TO: All Staff
FROM: Public Works Plan Review Team
DATE: March 8, 2022
SUBJECT: SX-22-00003 Ortado

Public Works has reviewed the Shoreline Exemption Application. Please see comments below:

**TOPOGRAPHIC SURVEY**  
**TAX PARCEL NUMBER 409134 - 4761 NELSON SIDING ROAD, CLE ELUM, WASHINGTON**  
 NE1/4 OF THE NE1/4 OF SECTION 29, TOWNSHIP 20 NORTH, RANGE 14 EAST, W.M.  
 FOR  
 KITTITAS COUNTY                      VINCENT AND ERIKA ORTADO                      WASHINGTON

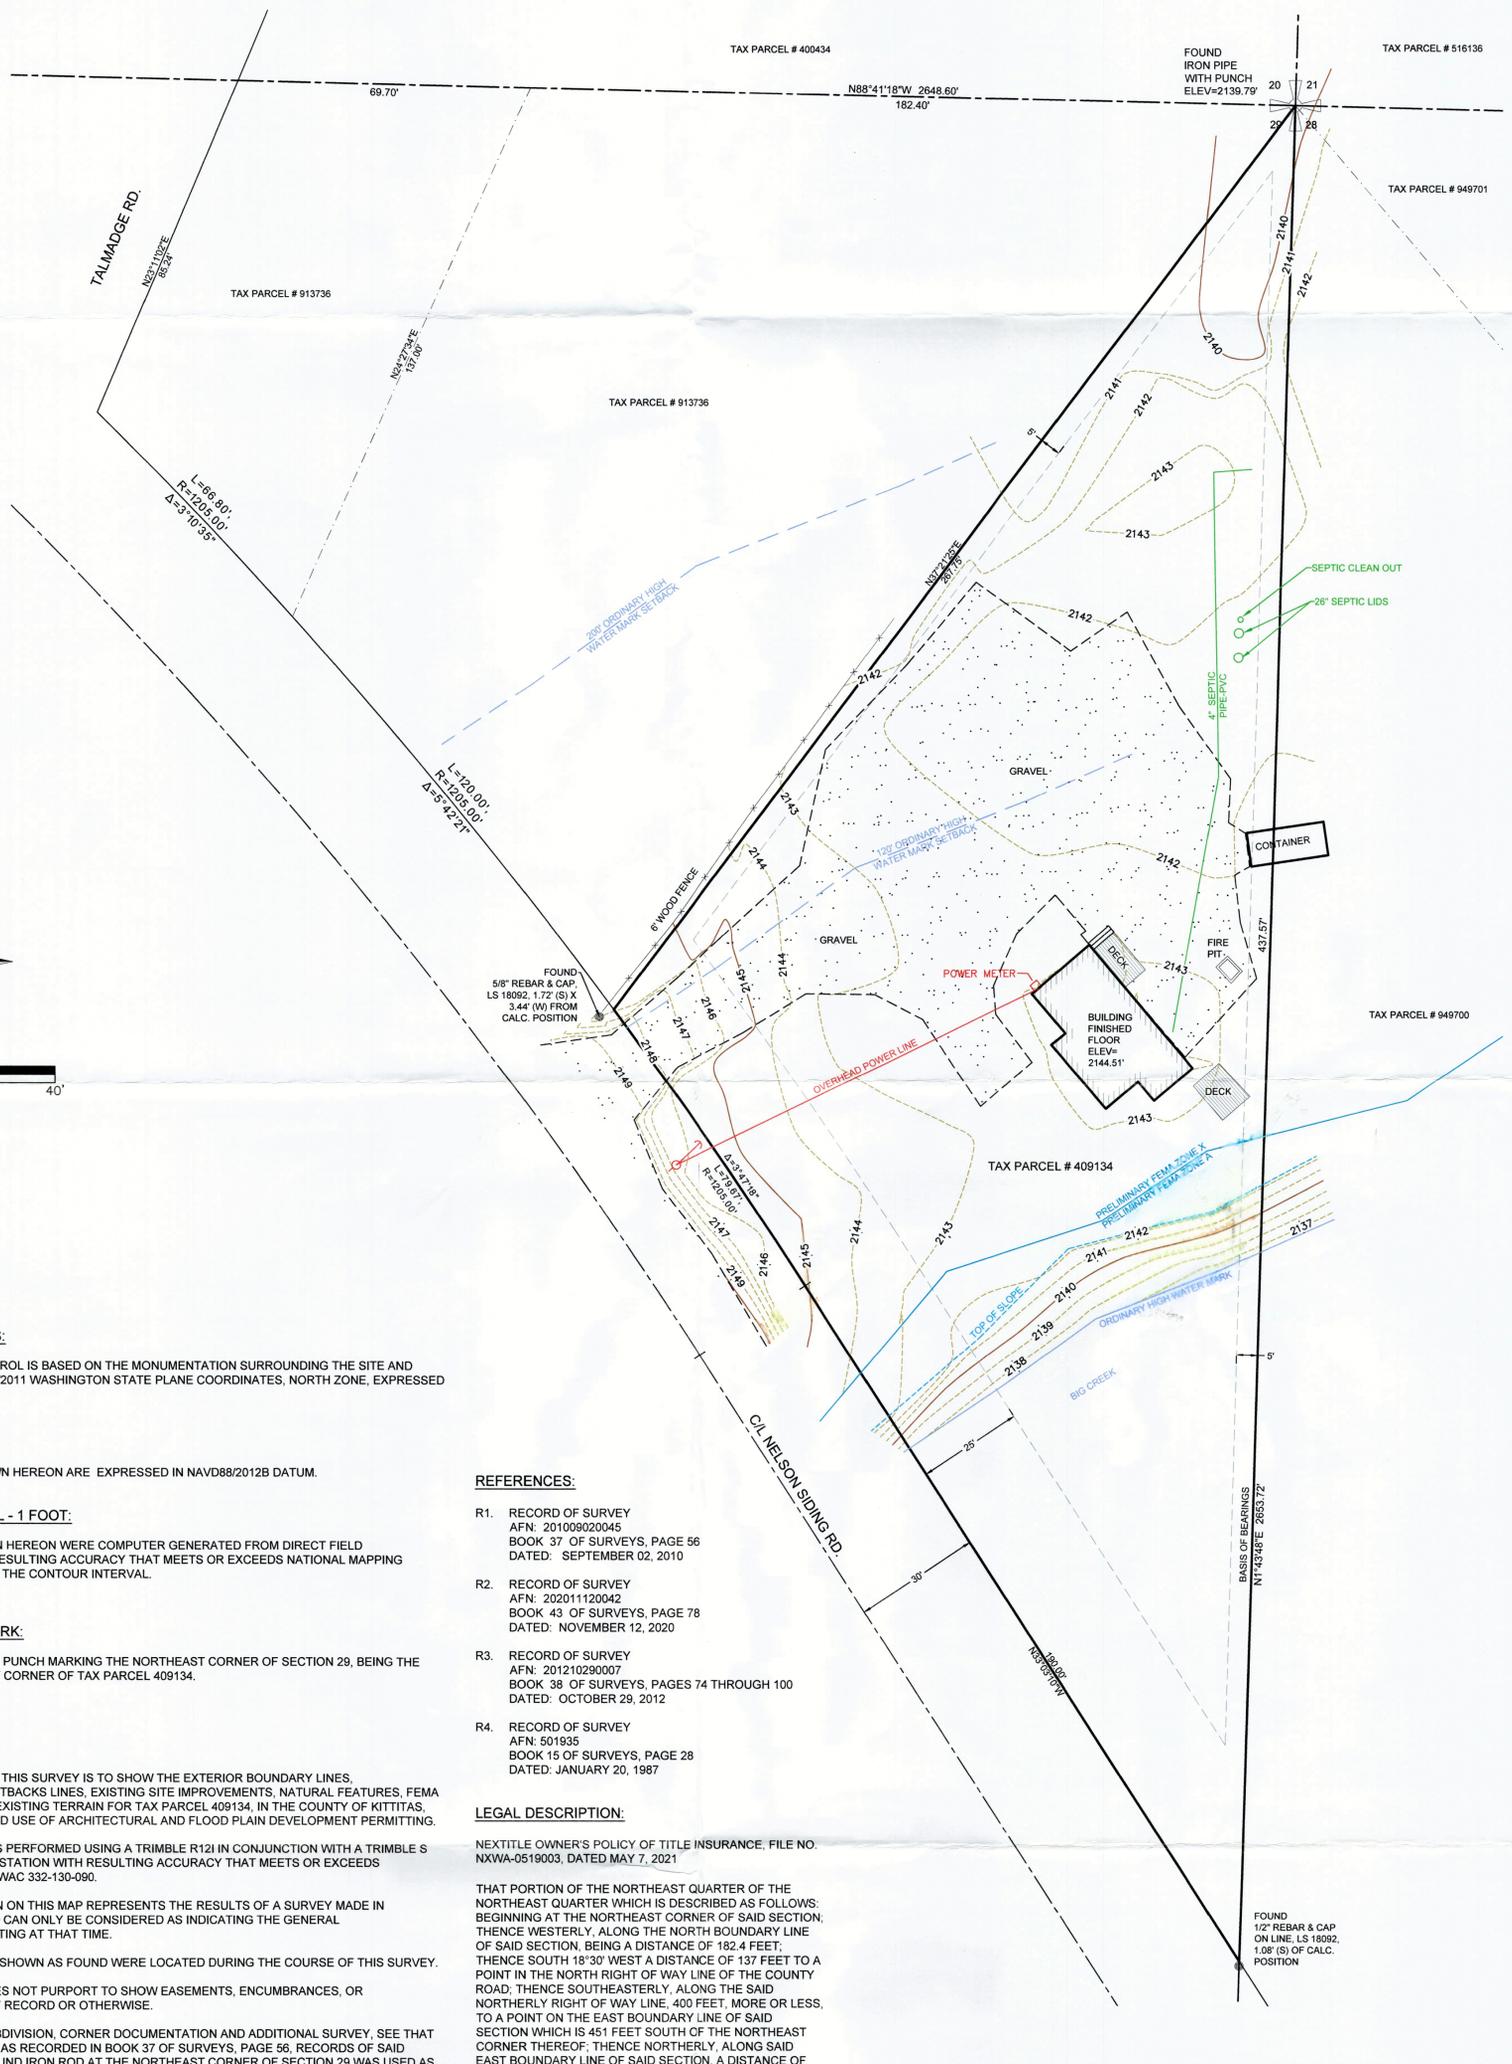
Based on the information available, granting the Shoreline Exemption to allow for the accessory building to be constructed in the location shown in the application is not expected to place the structure in an area with anticipated flood or channel migration risk. The proposed development is located outside of the Special Flood Hazard Area, as identified in the Flood Insurance Rate Study maps. A floodplain development permit is therefore not required. Since the entire parcel is within a planning-level identified CMZ the landowner may want to consider a hydrogeotechnical investigation of potential risk to the structure. However, there is no evidence of lateral erosion along the parcel significant enough to determine that Big Creek is reasonably likely to migrate to the proposed location for the accessory building. Further, natural channel migration processes are disrupted by Nelson Siding Road, further reducing the likelihood of channel migration affecting the location of the accessory building.
